**From:** Jeff Tarling  
**To:** Jean Fraser  
**CC:** David Margolis-Pineo  
**Date:** 1/22/2014 2:49 PM  
**Subject:** 118 Congress Street Project

118 Congress Street project / tree & landscape review comments:

LANDSCAPE PLAN
SCALE: 1" = 8'-0"

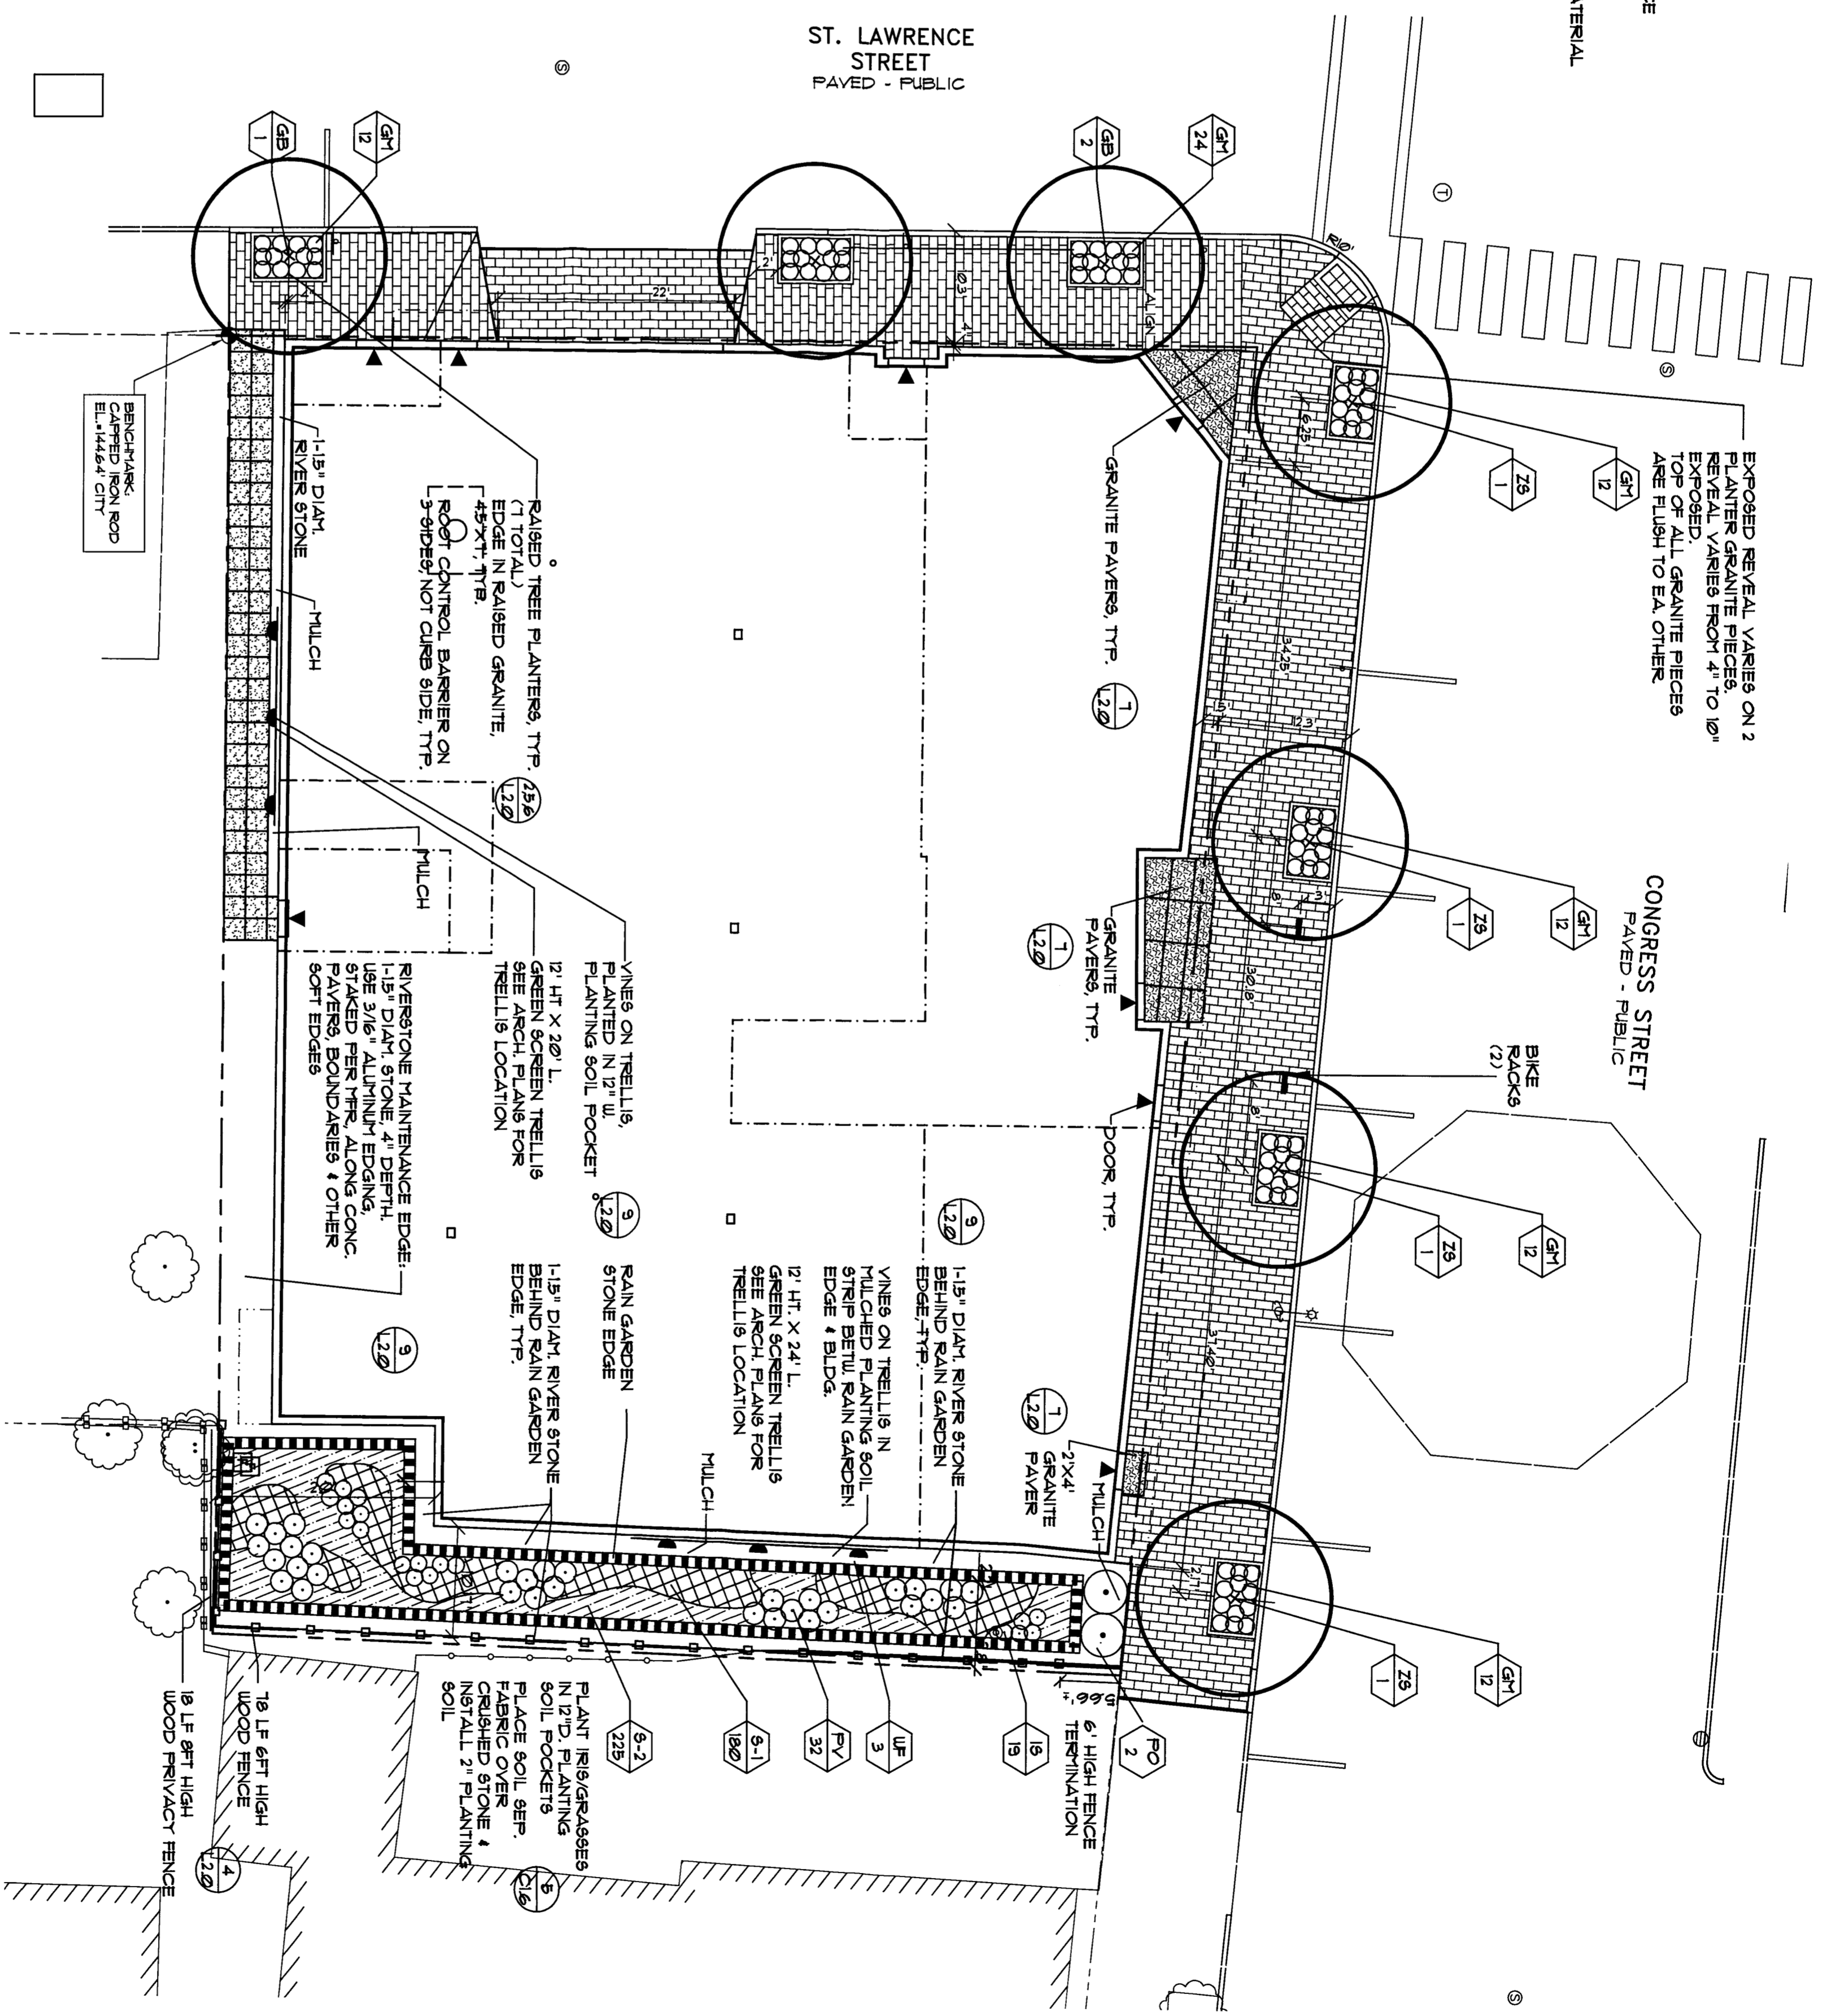
**a) Street-trees** - the project proposes to plant (6) street trees, (4) along Congress Street, 'save' the existing Pin Oak and plant (2) new on Saint Lawrence Street. Updated plan shows the trees planted in raised granite tree wells with herbaceous planting. If on-street parking is proposed, the tree spacing or setback away from the curb to prevent the opening of car doors is important. The trees can be placed to match the in-between on-street parking, making sure there is good access to the sidewalk from parked cars. The residential tree standard of one tree per unit would also be a condition. Building overhangs over the public way should be discouraged to allow the street tree growth.

**Tree types** - It would be ideal if the tree types along Congress Street are all the same species. I would recommend the Columnar 'Musashino' Zelkova to be ideal due to the narrow space. See <http://www.jfschmidt.com/articles/musashino> and photo below.

The 'Red Sunset' Maple crown shape is too broad for this space. Along Saint Lawrence Street again a more narrow tree is needed, it could be Ginkgo 'Magyar' or 'Autumn Gold' cultivar (seedless), due to narrow sidewalk space. (photo 'Musashino' Zelkova, narrow vase shape crown)

**b) Landscape** - The recent revision adds herbaceous planting to the tree planters and the 'backyard' / rain-garden edge. Additional screening to the adjacent property should be considered, this might be achieved by adding higher branching landscape planting or higher fencing (5'). The rain-garden planting with mostly herbaceous plant material will reach a low height. It does not appear to meet the B-1 Zone landscape standard ( i ) " A densely planted buffer and / or fencing will be required to protect neighboring properties..." Suggestions could including some taller shrub plants along with a higher wooden fence. The Green Wall proposed will also help screen the building. Additional green-wall / landscape planting could be used on the West elevation to the left of the garage door, this area seems blank; and to the left of the center door on Congress Street away from the overhead canopy.

5 RAISED GRANITE PLANTER - ISOMETRIC VIEW (AT CURB RAMP ON CONGRESS STREET)
L2.0 NOT TO SCALE

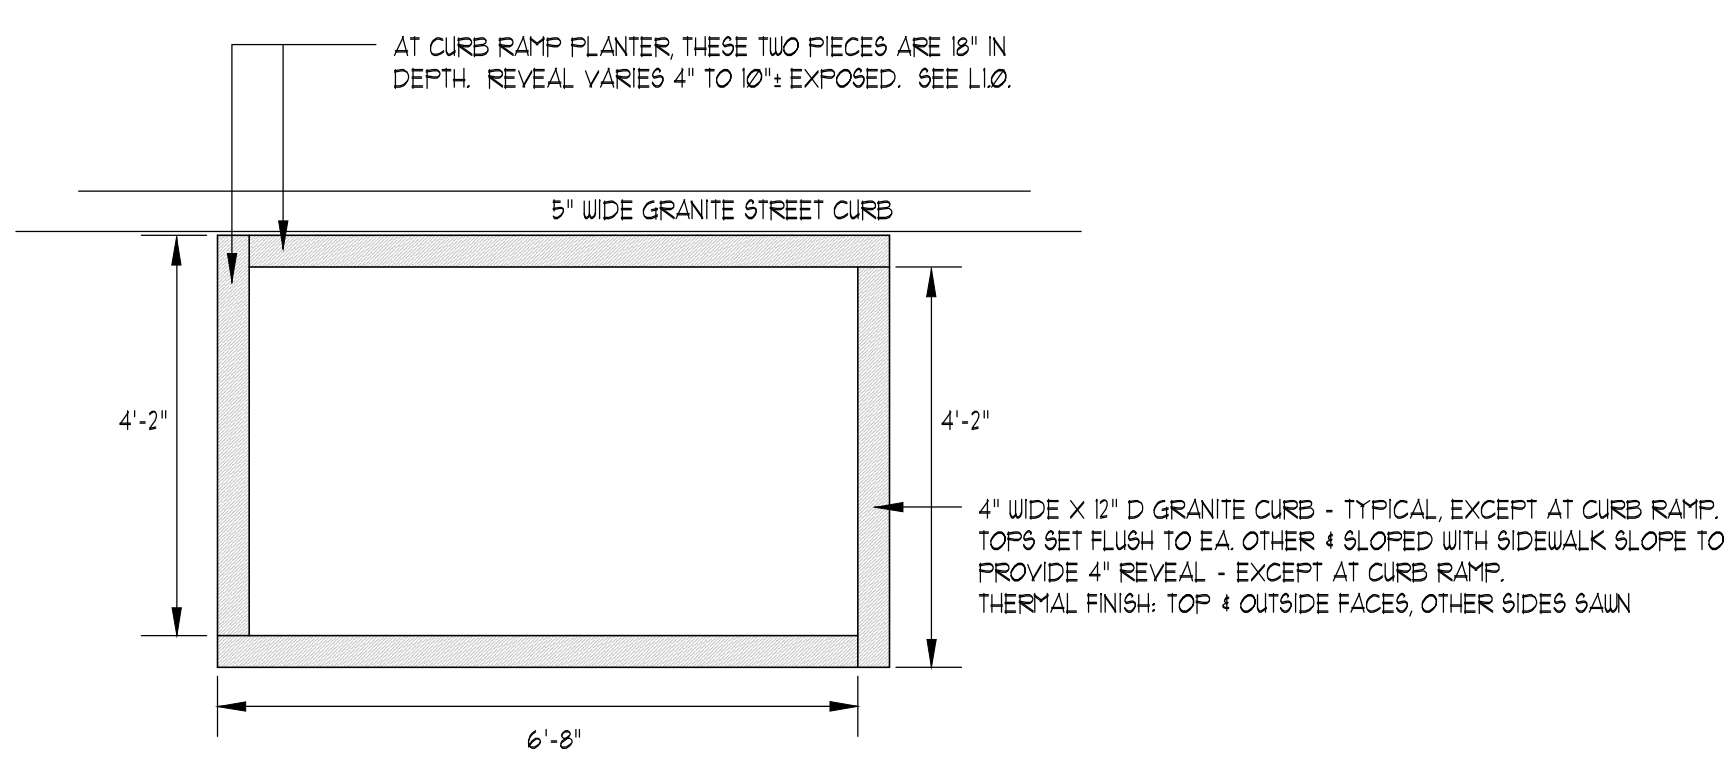
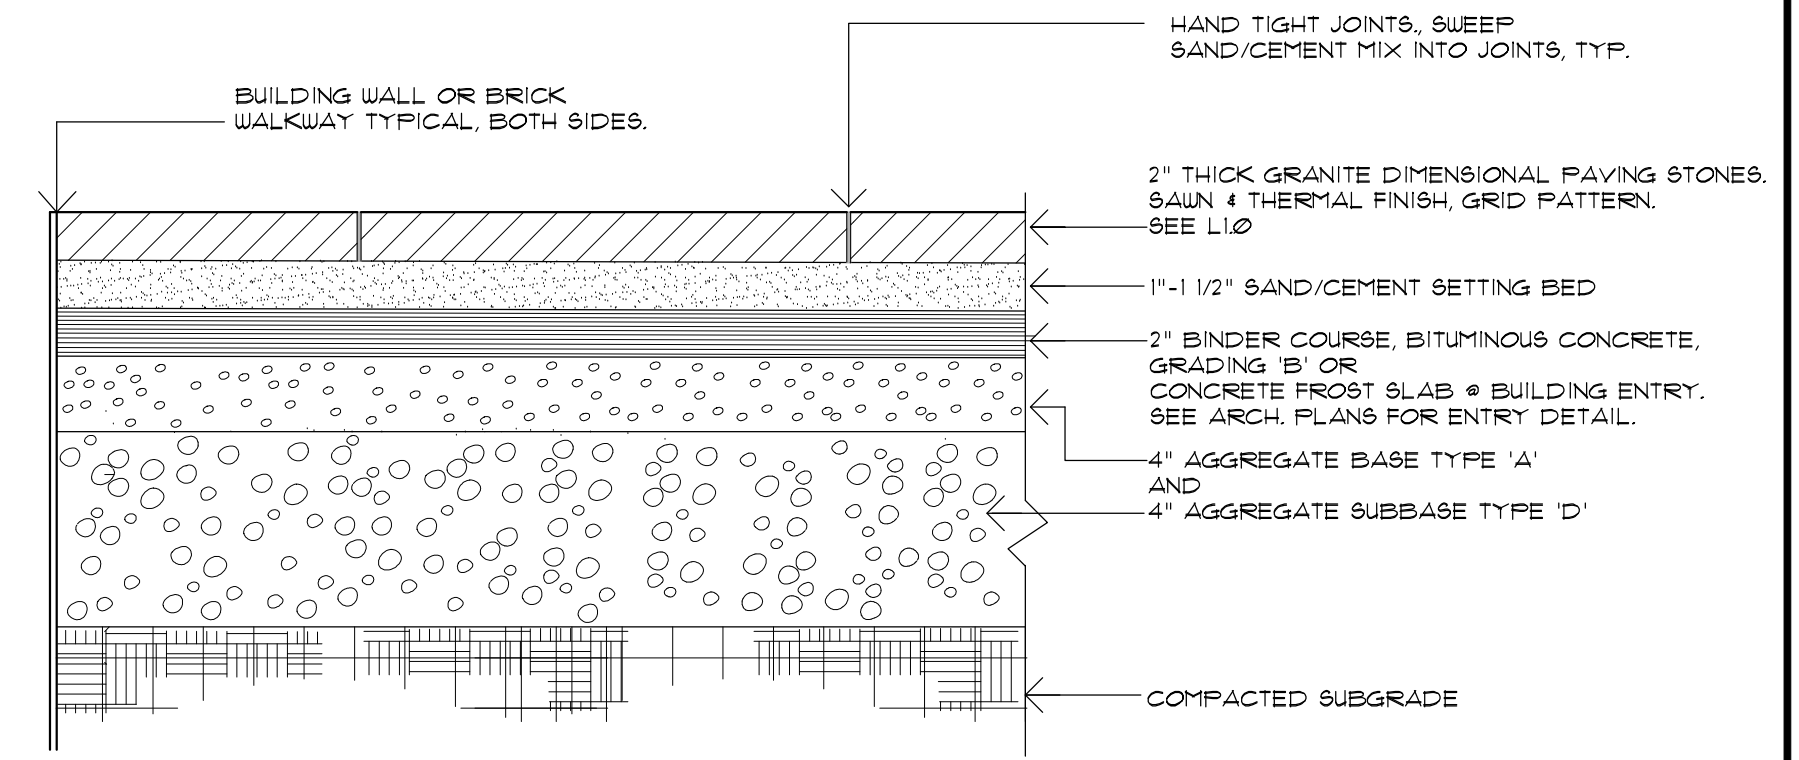
**Granite planters in right of way** - the six granite planters are proposed to be planted with street-trees and 'Cranesbill', perennial geranium. This will add interest to the typical mulched tree well. Long term however it is unlikely the city would be able to maintain these plantings. Ideally, the project could adopt the tree wells and maintain the landscape planting.

7  
L2.0  
NOT TO SCALE  
EXISTING TREE PROTECTIVE FENCING (FOR PIN OAK)

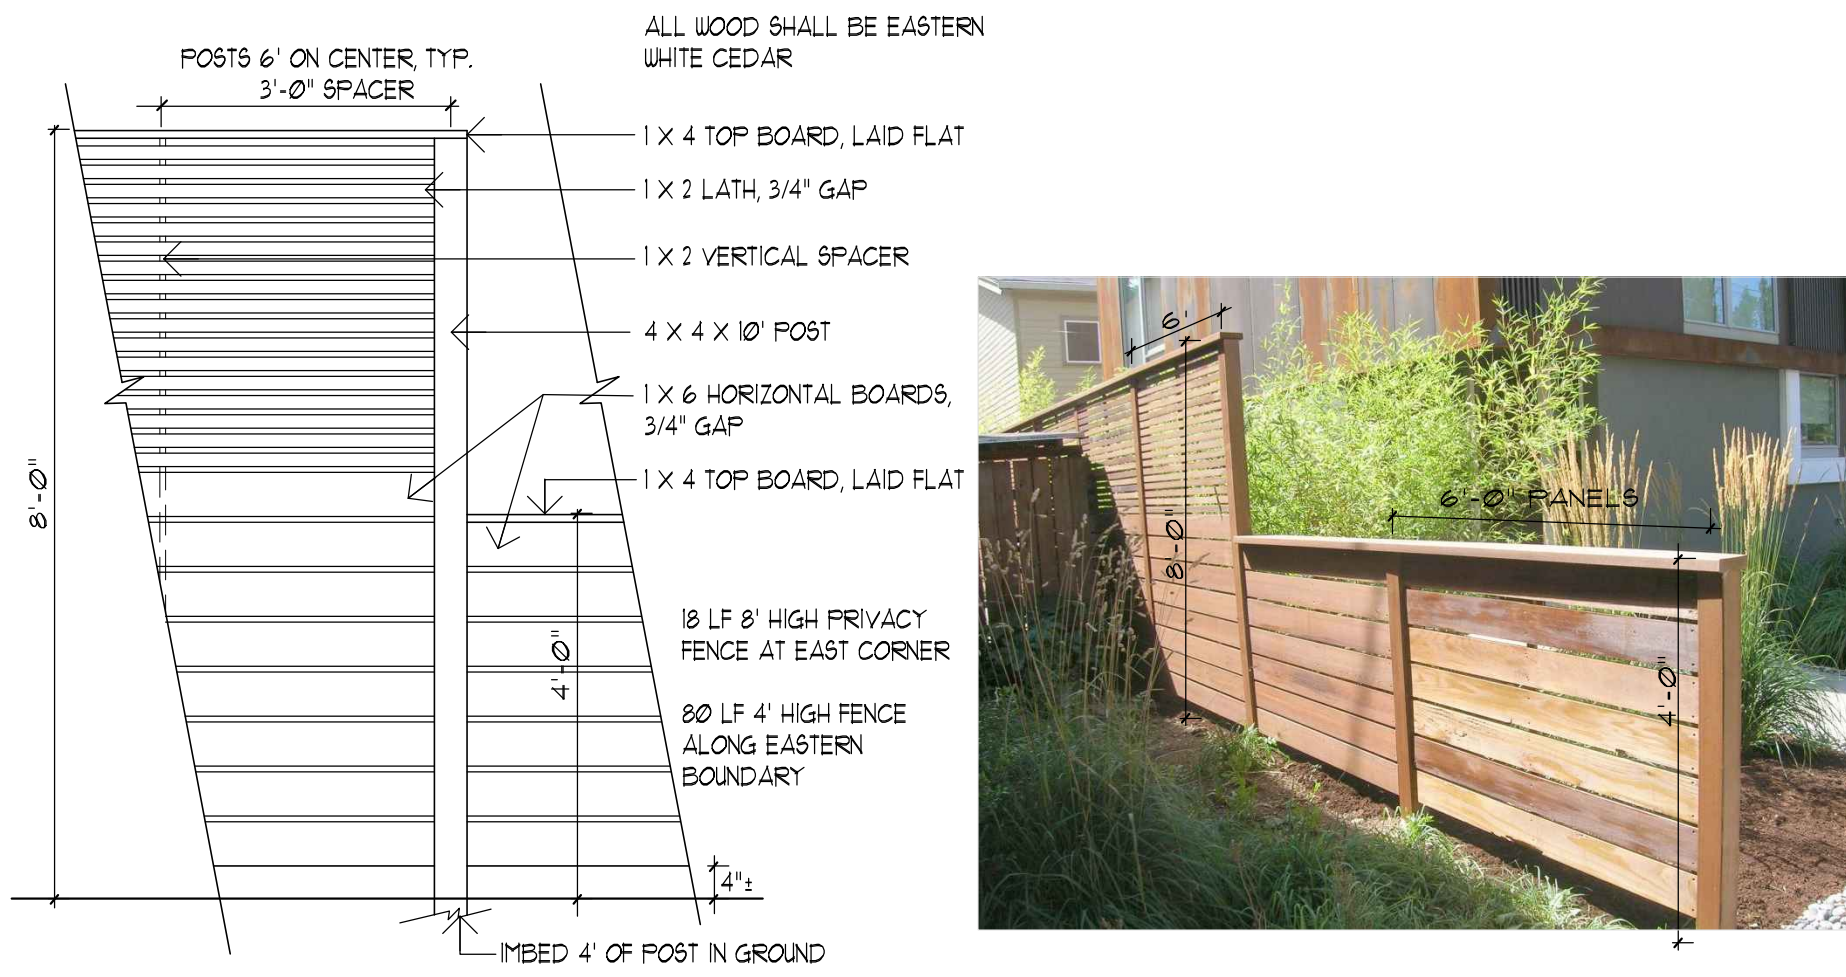
**'Tree Save'** - I was hoping the project could protect or save the large Pin Oak on Saint Lawrence Street, while the recent plan does show this, a recent site visit confirmed the crown of the tree would be severely impacted or one-sided, thus reluctantly yield to the fate of removal due to proposed building location. An additional street tree would be requested. Also, the proposed new tree on Congress Street near the corner of Saint Lawrence should be shifted slightly away from the intersection perhaps 2 - 3'. The recently planted American Elm along Congress Street should be saved and replanted by the city.
